330 CHURCH STREET, PARRAMATTA

S75W ACCESS REVIEW

Morris-Goding Accessibility Consulting

28th May 2013

PROJECT		
RIVERFRONT APARTMENTS 330 CHURCH STREET PARRAMATTA NSW		
DRAWING NAME		
Plan_Level 00 Retail

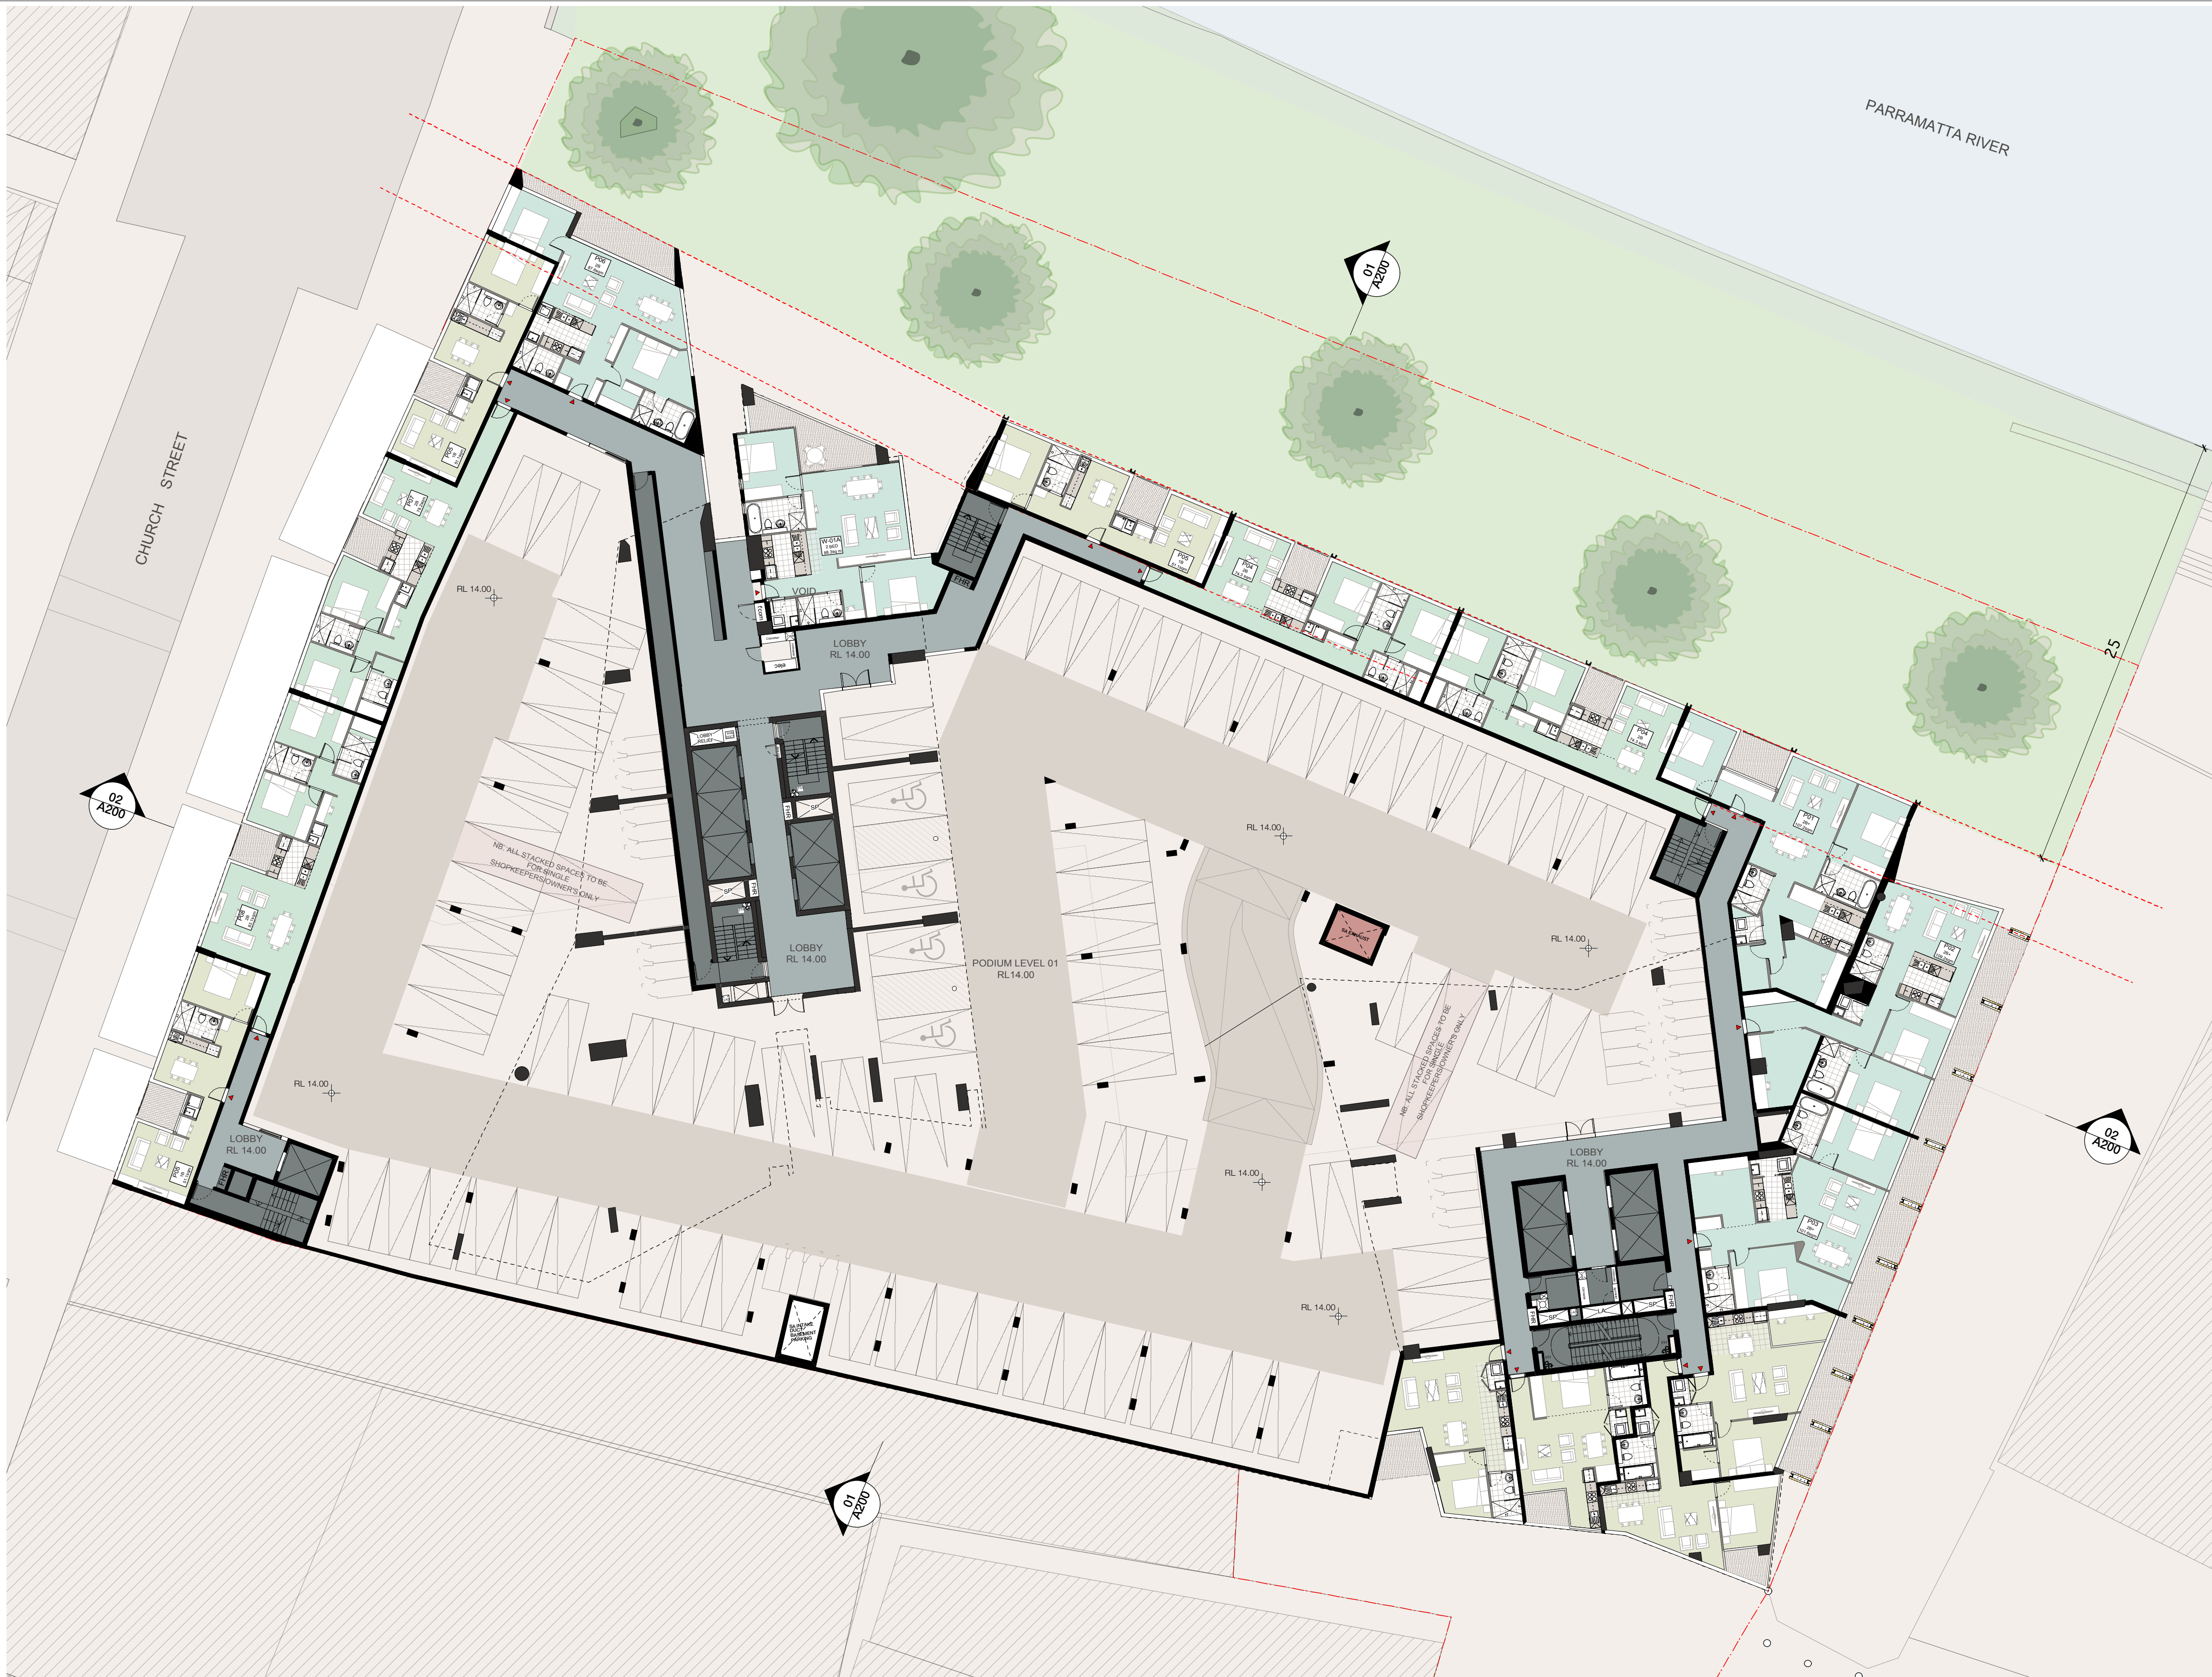
From the bottom of the ramp, there is a continuous accessible path of travel to the East Building entry, compliant with AS1428.1:2009, clause 6.1. Entry into the East Building lobby is currently shown to be a revolving door. A suitable accessible entry is required to comply with the DDA Premises Standards and AS1428.1:2009.

- (i) Ensure the entry ramp into the building has a suitable gradient (maximum 1:14) with appropriate landings at 9m intervals compliant with AS1428.1:2009.
- (ii) Provide a suitable accessible entry door with an 850mm clear width (920mm door leaf) adjacent to the revolving door compliant with AS1428.1:2009.

PROJECT  
**RIVERFRONT APARTMENTS**  
330 CHURCH STREET  
PARRAMATTA NSW  
DRAWING NAME  
**Plan\_Typical Tower Upper**

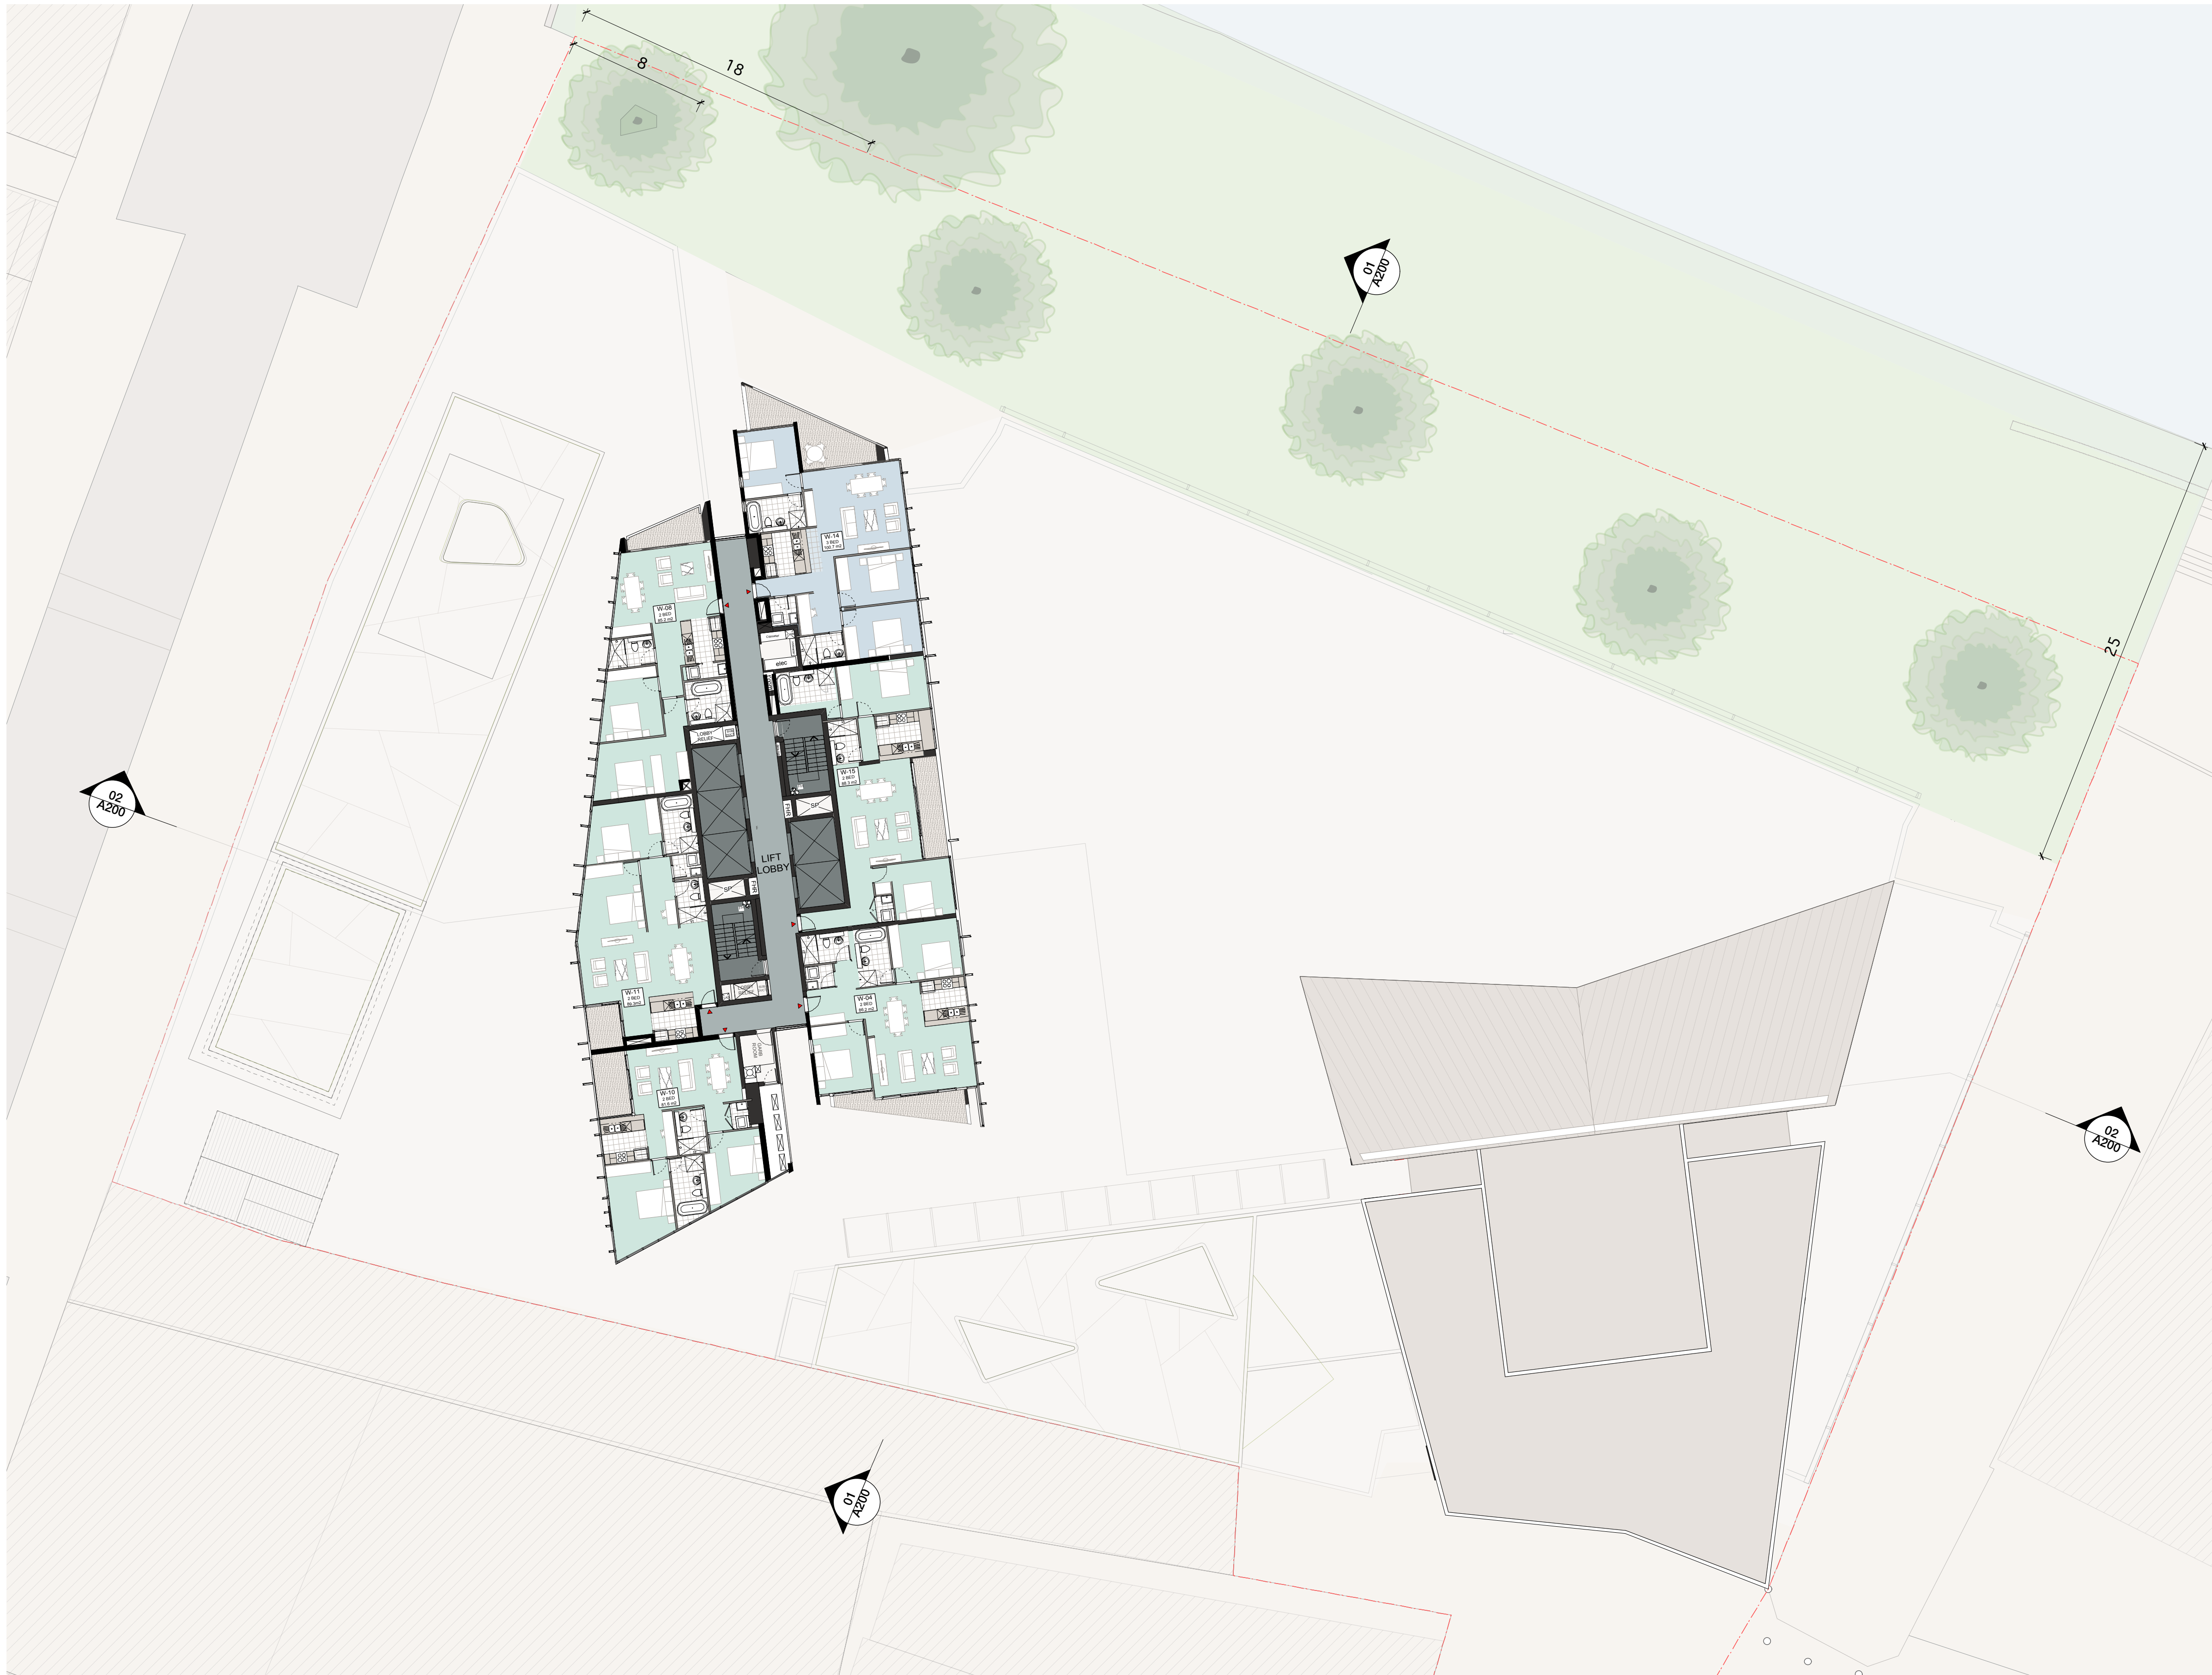
- (ii) Ensure suitable 1540mm x 2070mm clearances within 2m of the ends of corridors to allow a person in a wheelchair to perform 180° turns compliant with AS1428.1:2009.
